**WEST SUSSEX COUNTY COUNCIL
INFRASTRUCTURE CONSULTATION**

**SUBJECT: LU/105/09/ - Amendments to approved appl. LU/359/08 for new garage -
WSCC not consulted**

25, Maxwell Road, Littlehampton, West Sussex, BN17 7BW

6294 09A

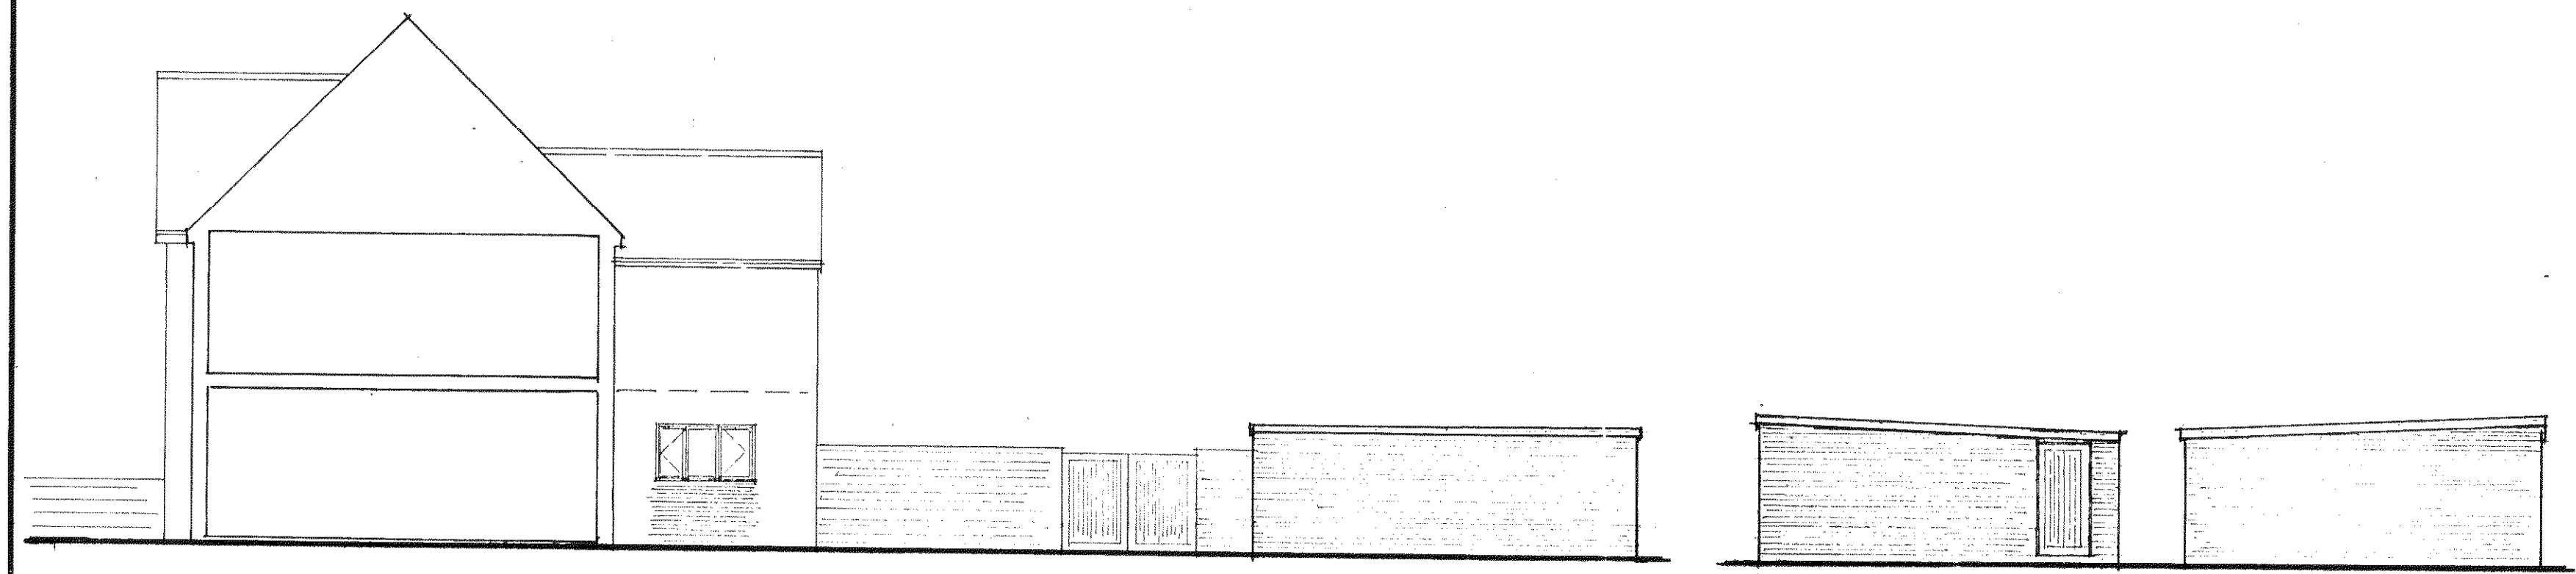
The proposed amendment to the approved garages would result in up and over garages doors projecting over the public footway to the detriment of highway safety.
